Your Ref: OWPC19920
Our Ref: EP/100/18/PL 24-06-2018
Please ask for:
Zac Denton

Conservatory to rear elevation.
6 Langmeads Close East Preston

EAST ELEVATION

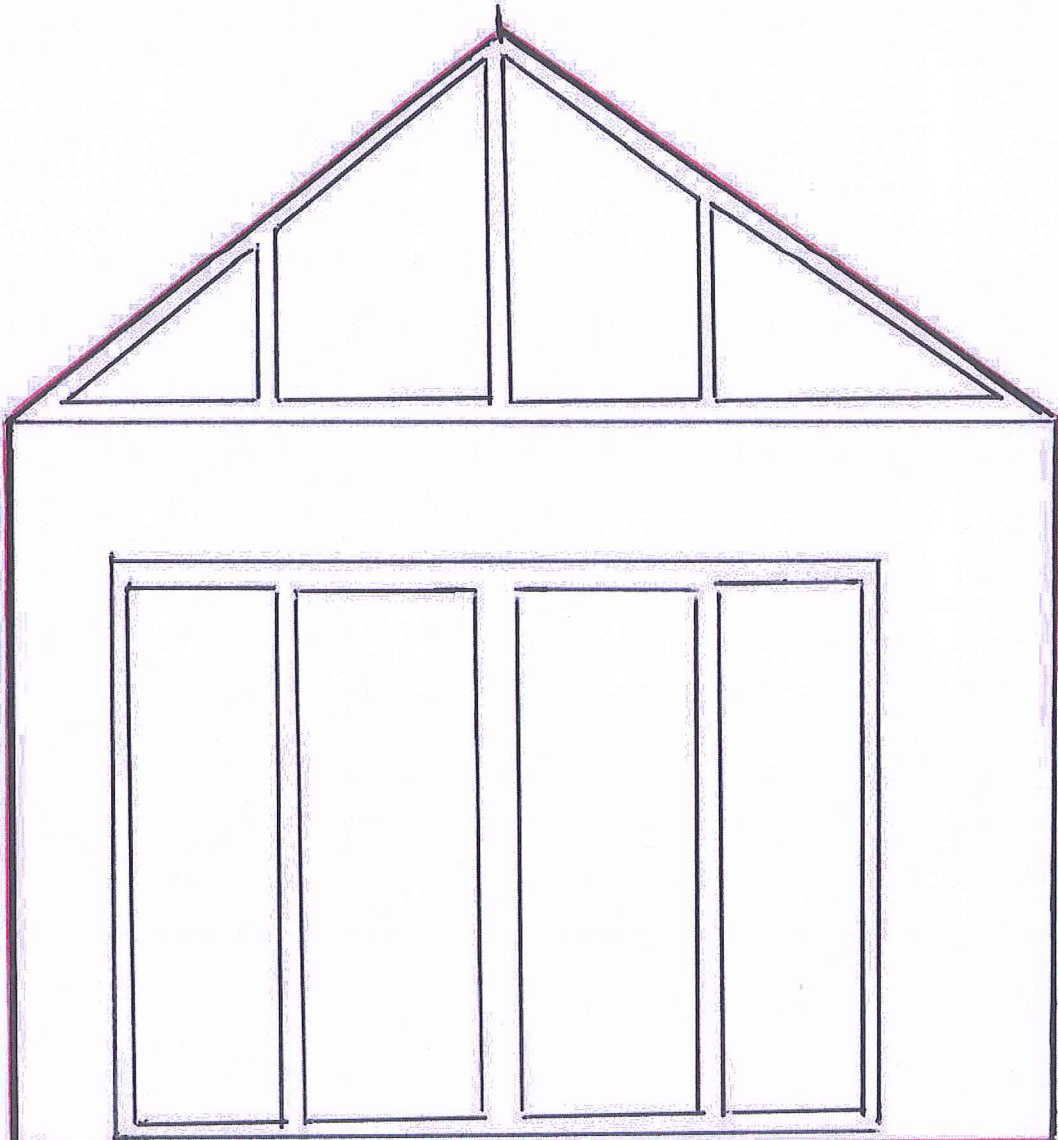
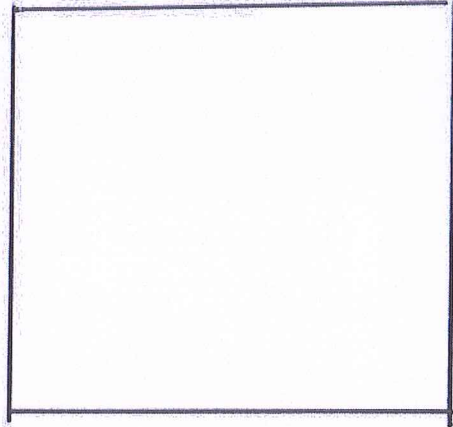
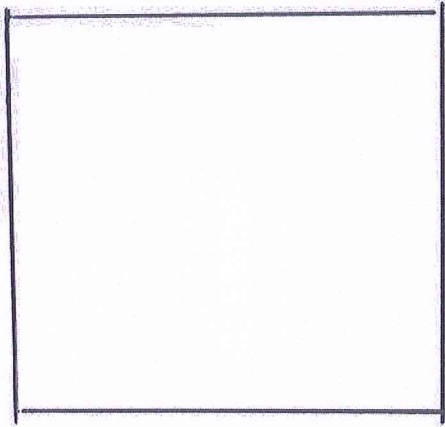
The plans on the submission are not to scale and do not demonstrate the true size of the conservatory. The length is 3.10m and width 4.70m, yet the hand drawn plans suggest the conservatory is much smaller. The plans state the current length of the garden is 10.50m and the conservatory will be 3.10m from the rear off the house, meaning it will take up nearly a third of the garden. This is disproportionate to anything else in the surrounding houses and a large footprint on the green space around the property.

More concerning is the height of the conservatory and the impact this will have on the light into our property. The plans suggest the conservatory will 2.90m high and due to the size of the conservatory will block a significant amount of light into our garden and lounge. This will also affect 5 Langmeads Close to a greater degree due to the position of the sun during the day.

In the original application it is stated that there are properties on a nearby development with conservatories. Whilst this is true, they are much smaller and more proportional to the size of the house and garden. They also have flat sloping roofs which are far less obtrusive and would block less light. We would not have any objections if the proposed conservatory was identical to these in size and design.
